# Final Plat Comment responses.pdf Markup Summary

**Subject:** Callout  
**Page Label:** Sheet 1 - Cover  
**Author:** Carlos  
**Date:** 7/5/2023 11:23:57 AM  
**Status:**  
**Color:** ■  
**Layer:**  
**Space:**

**Subject:** Planner  
**Page Label:** Sheet 3 - As Replatted  
**Author:** Kylie Bagley  
**Date:** 7/6/2023 8:04:32 AM  
**Status:**  
**Color:** ■  
**Layer:**  
**Space:**

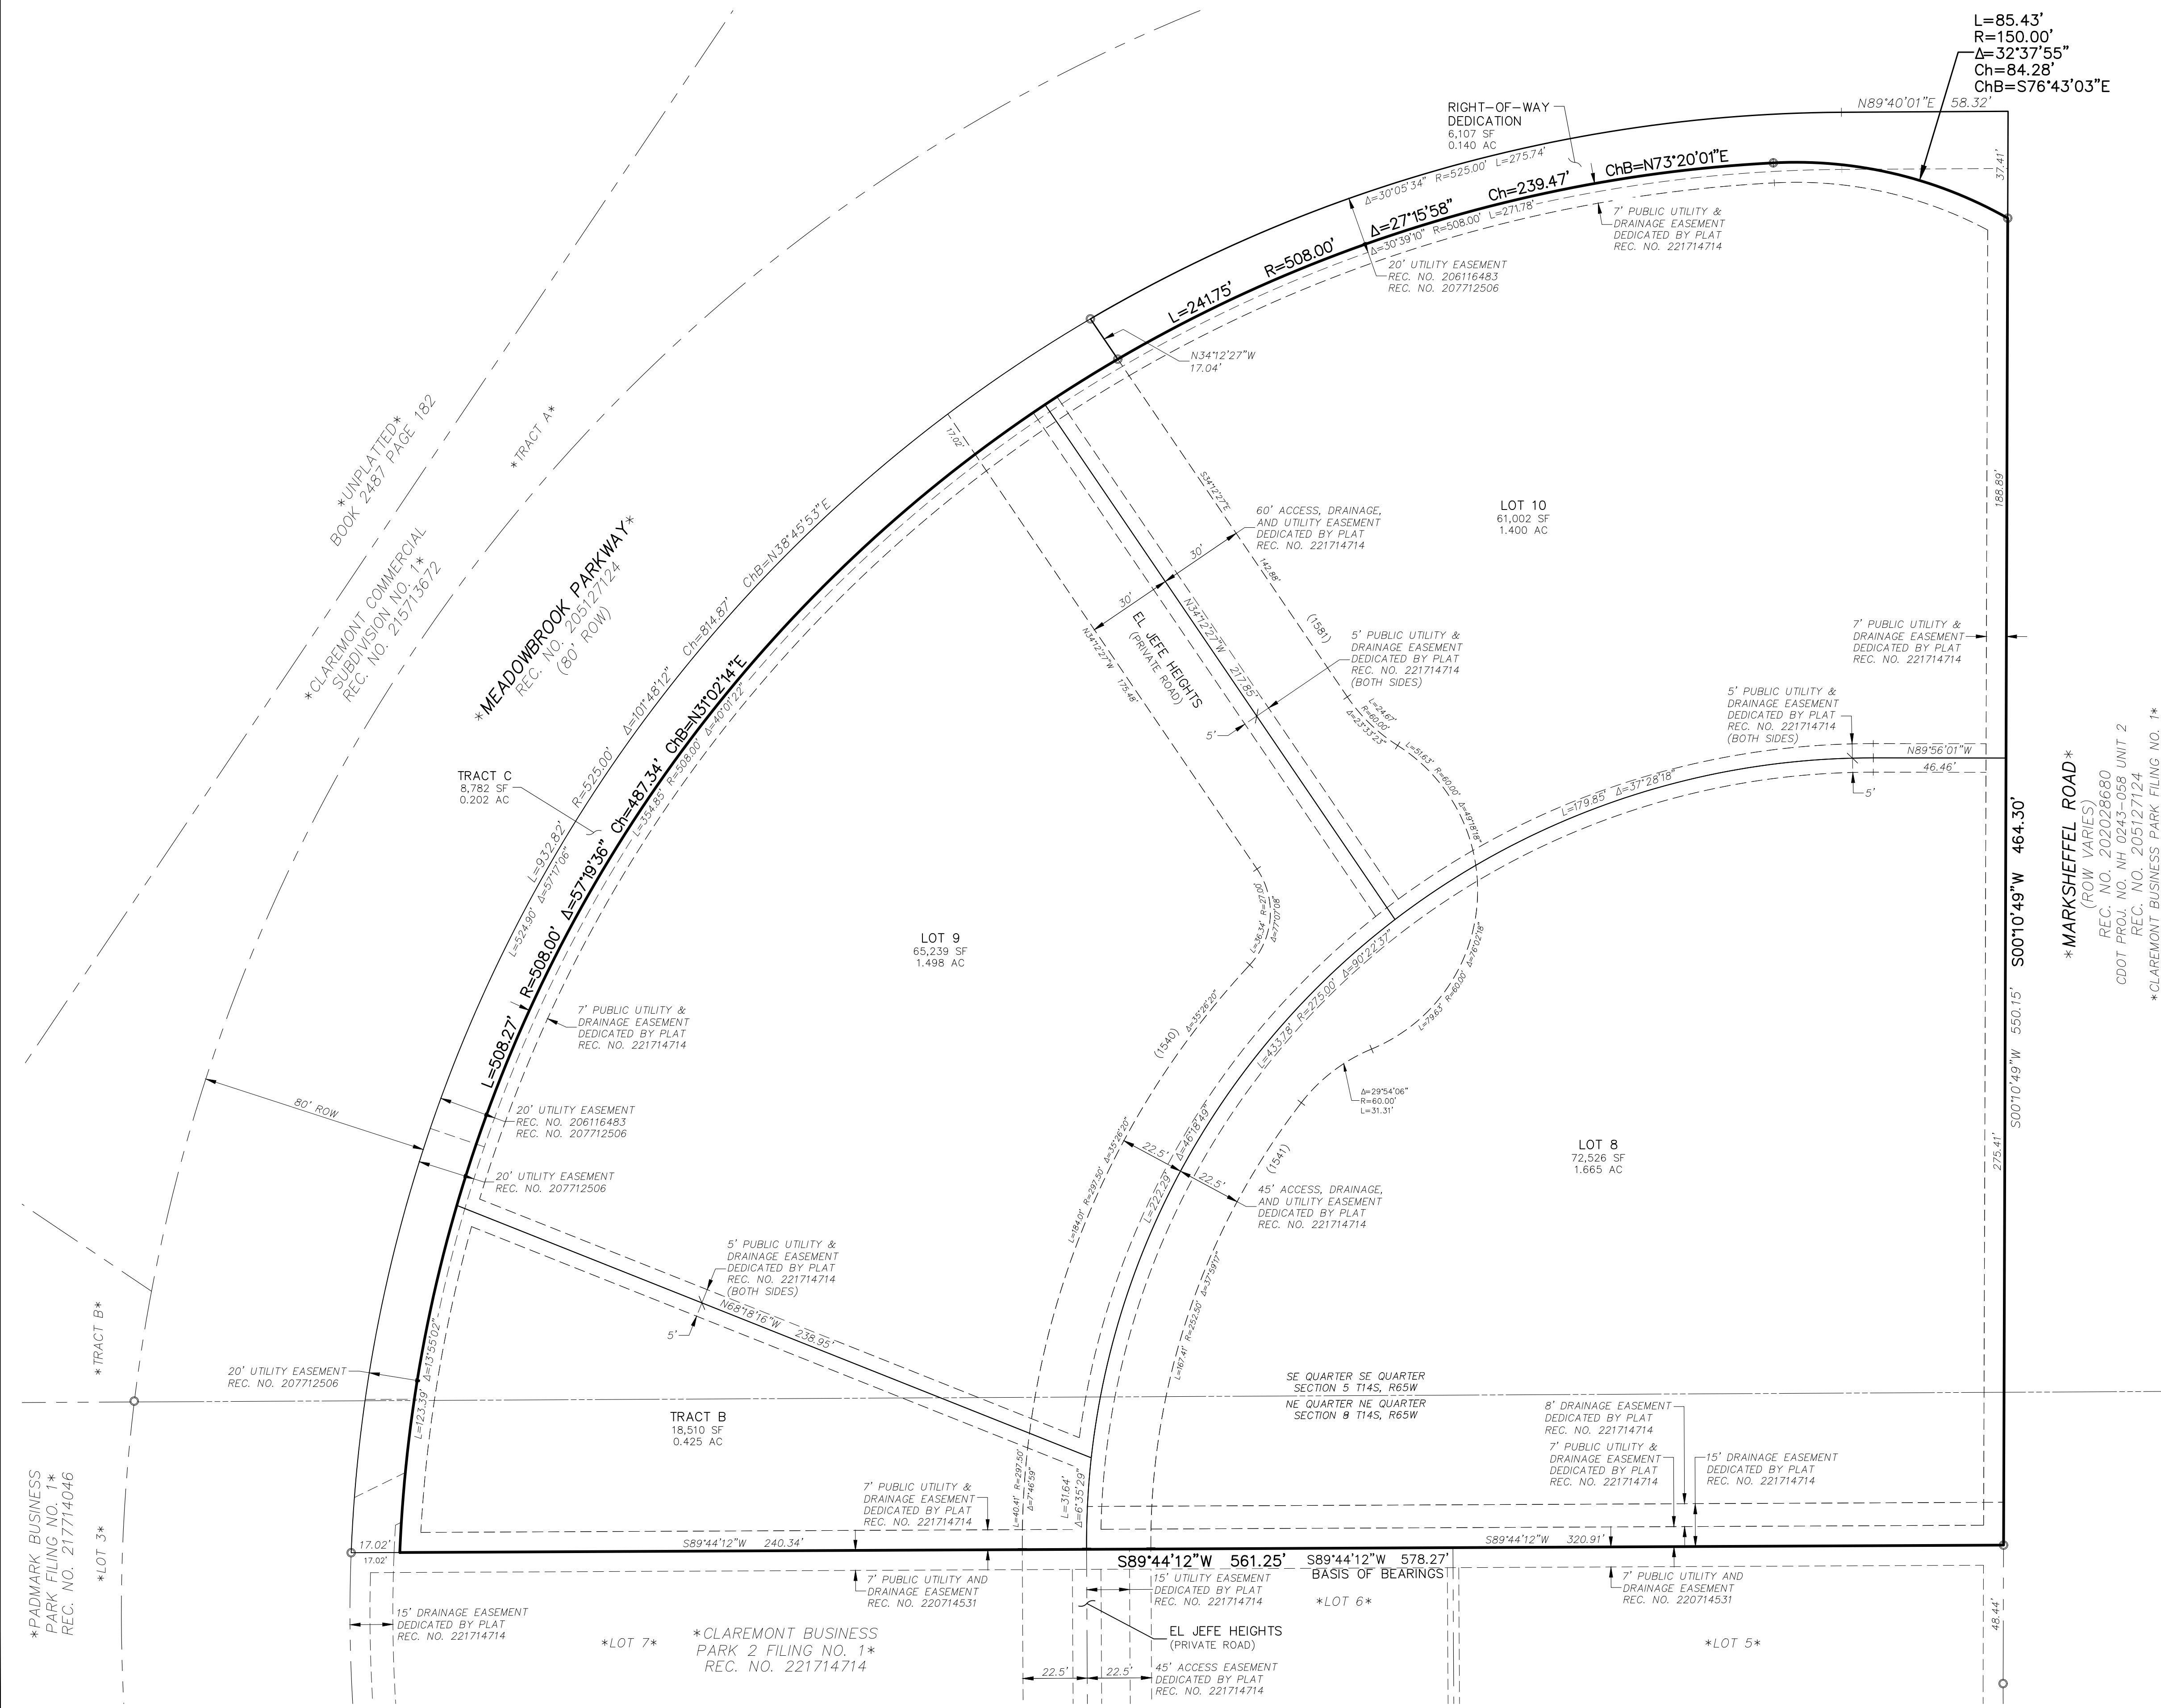
Note 12 is a duplicate of note 8, please remove.

Note 12 deleted. Subsequent plat notes renumbered accordingly.

CLAREMONT BUSINESS PARK 2 FILING NO. 2

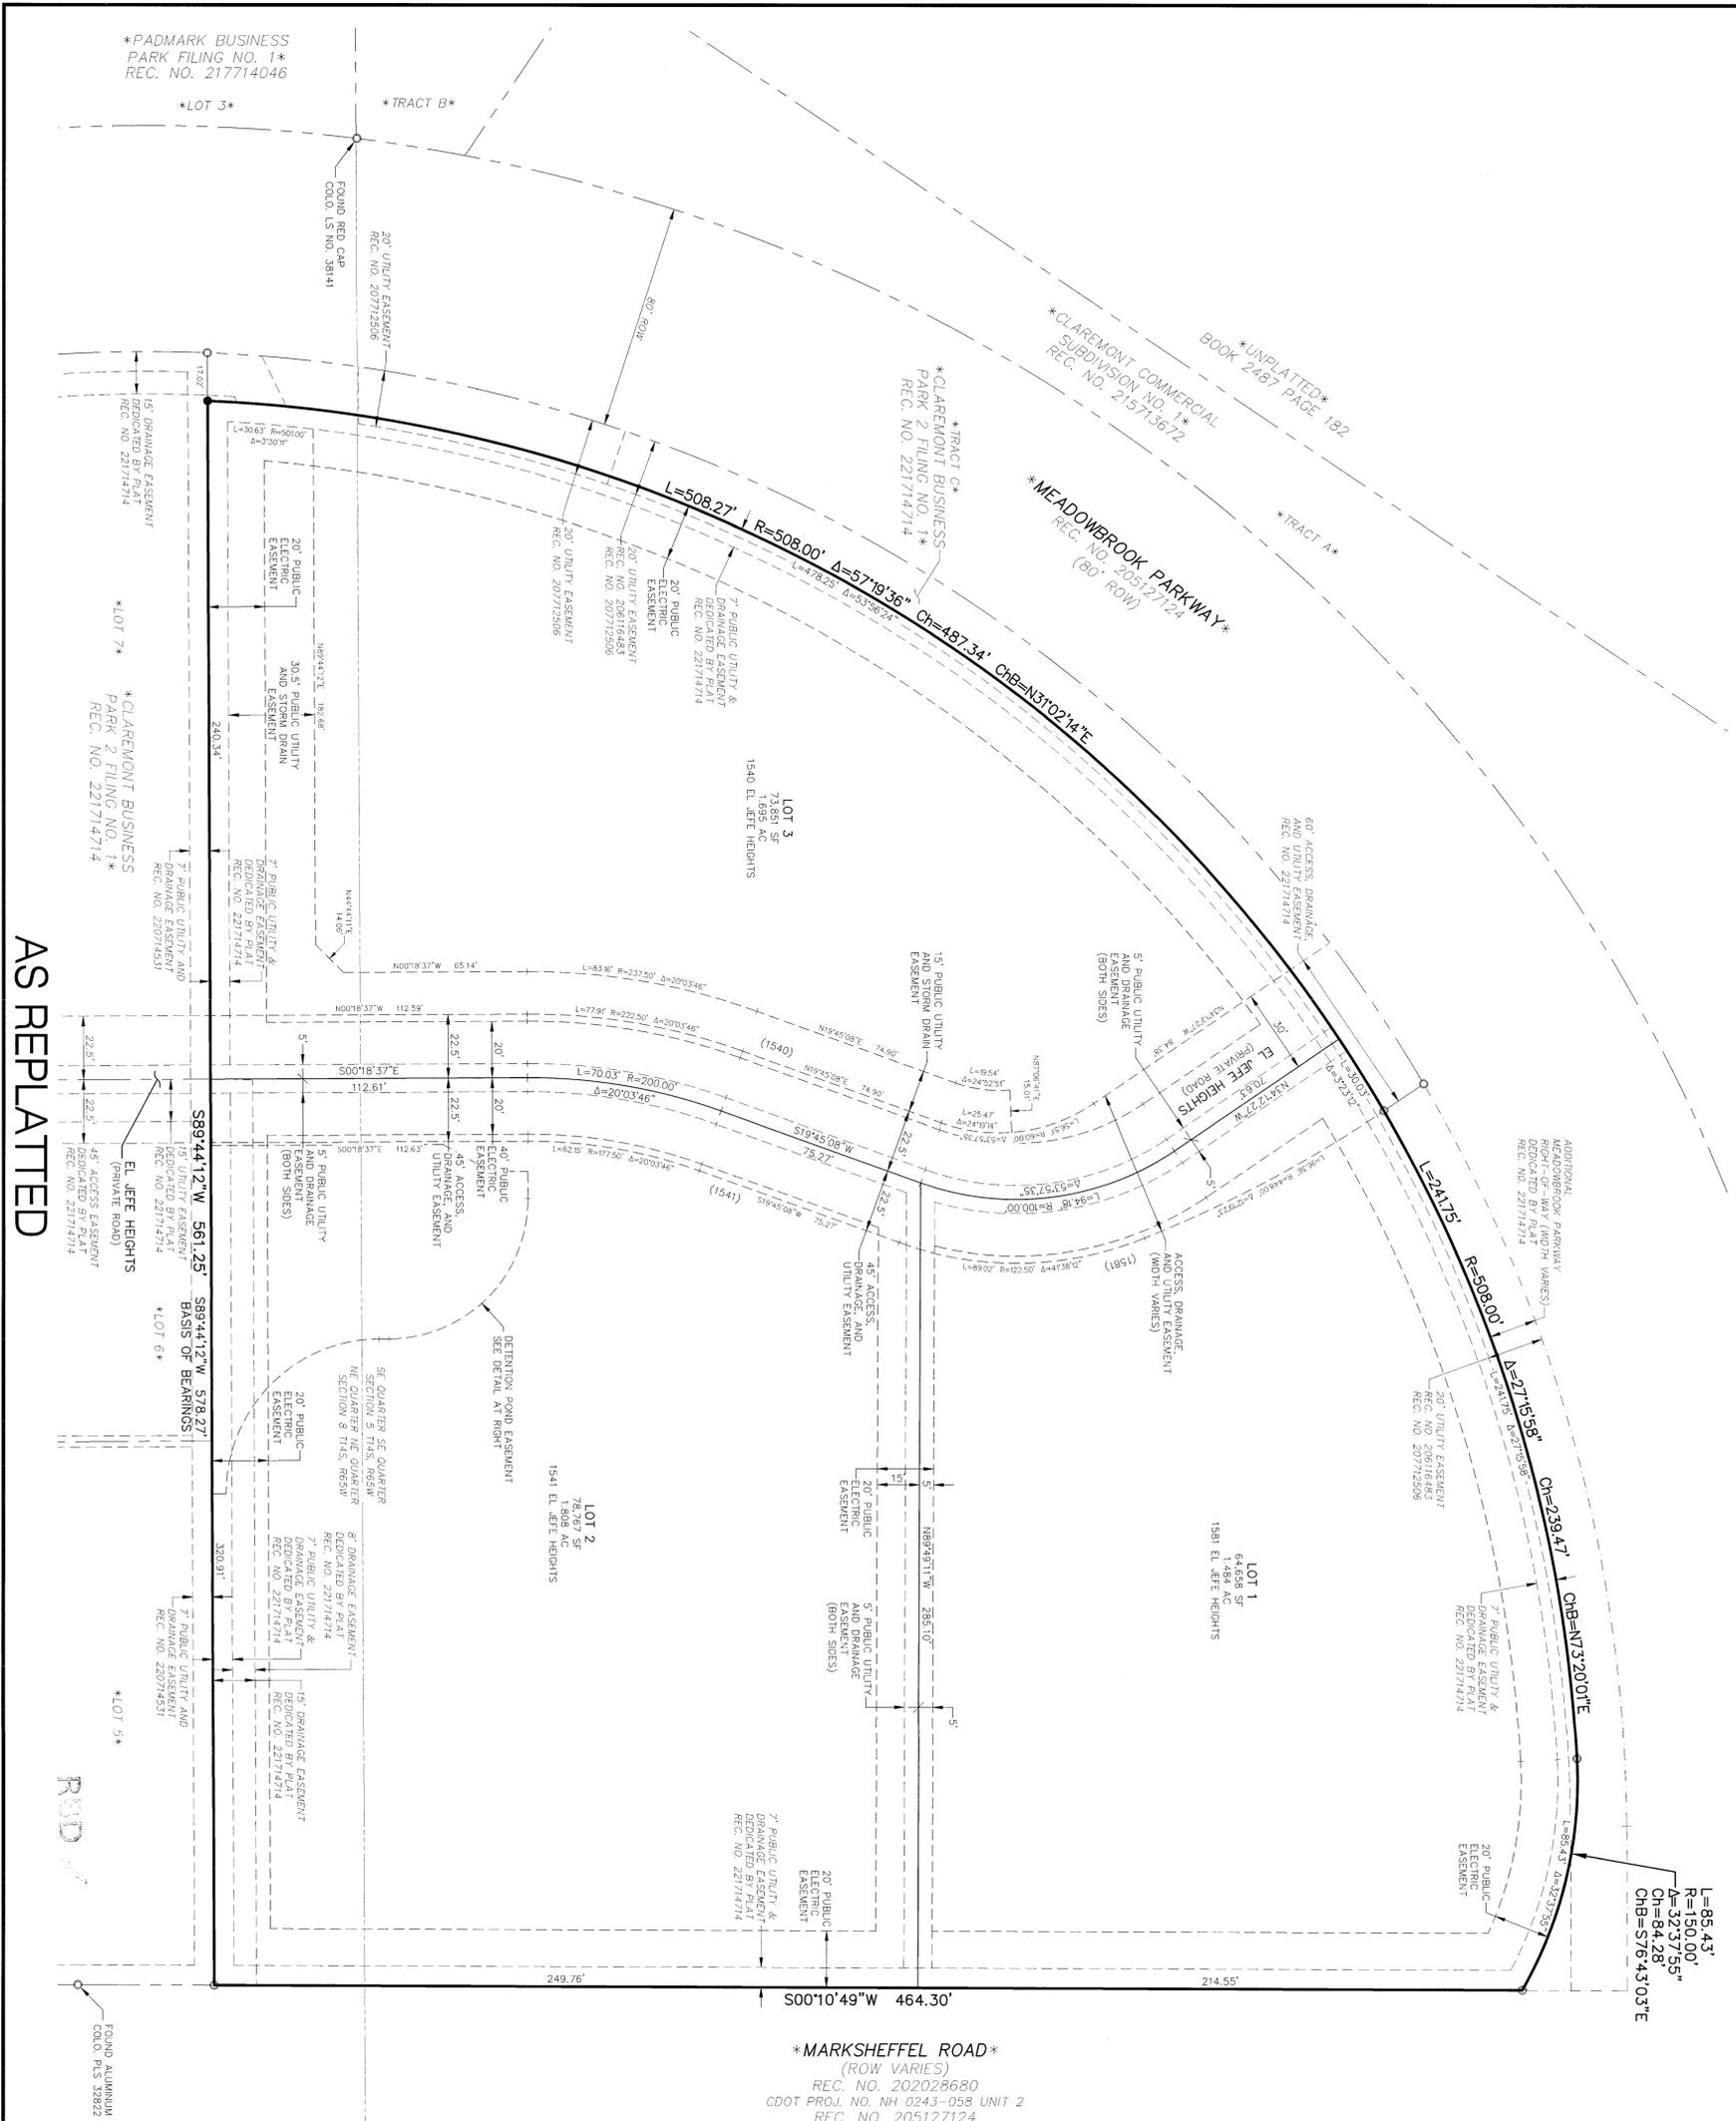
Add addresses from PPRBD

Proposed pond easement(s) not shown on Plat, contrary to what you said on the GEC Responses document.

Unresolved Review 1 Comment:  
Please show drainage easements on the plat for  
pond locations.

Addresses are shown on plat; however, to make them more clear, they have been incorporated into the lot labels. (On both "As Platted" and "As Replatted" sheets.)

Detention pond easement added to plat.

Detention pond easement added to plat in addition  
to drainage easements already shown and labeled.
